The Planning Inspectorate

Appeal Reference: APP/C3105/W/17/3191148

Site Address
Heyford Park Parcel B2A
Camp Road
Upper Heyford
OX25 5HA
Grid Ref Easting: 450796
Grid Ref Northing: 225846

Please note this is a generic and neutral statement as I am not permitted to appeal a Bovis application directly.

DRAWING TITLE: **LOTS 79-178 & 265-268 & 299**
FENCE KEY PLAN

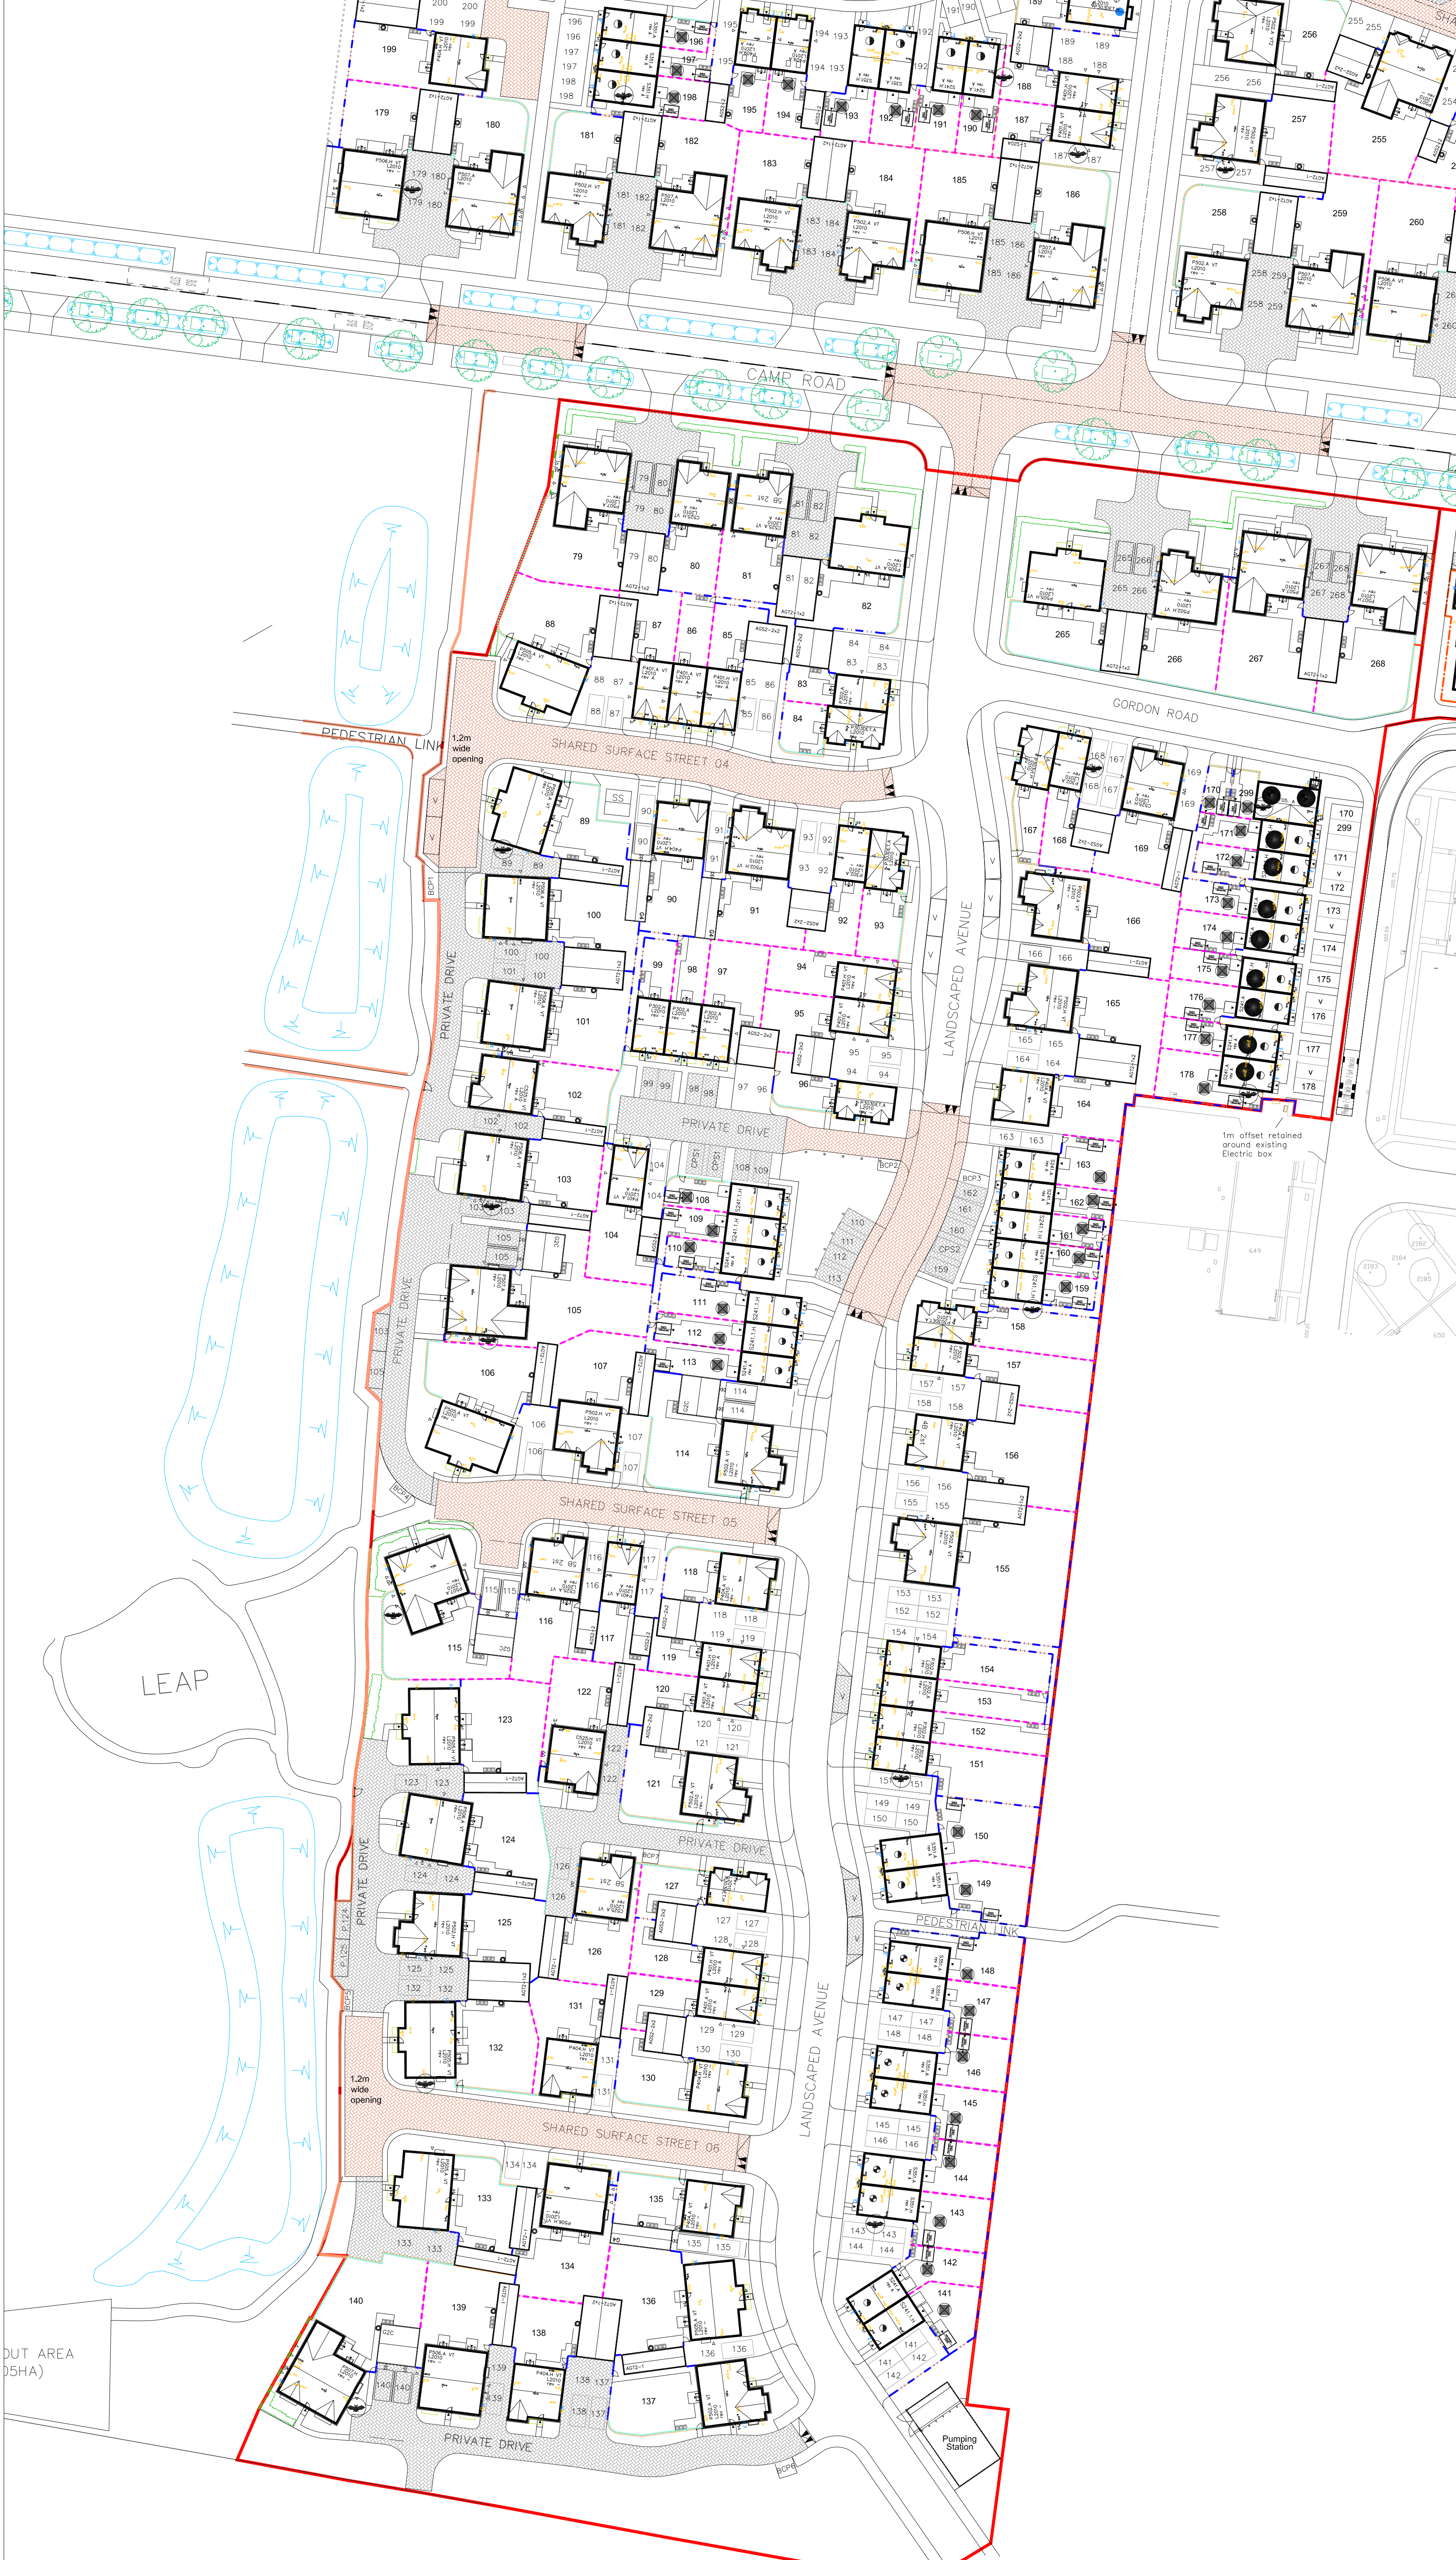
Poor visibility at night of black railing and resident controlled lighting, causing potential loss of sight if lighting is not operative

Limited access points causing children and adults to climb over the railings to gain park access

Utilisation of residence front gardens and private property being used as short cut access to park areas

Railings located on residents properties causing liability of the above
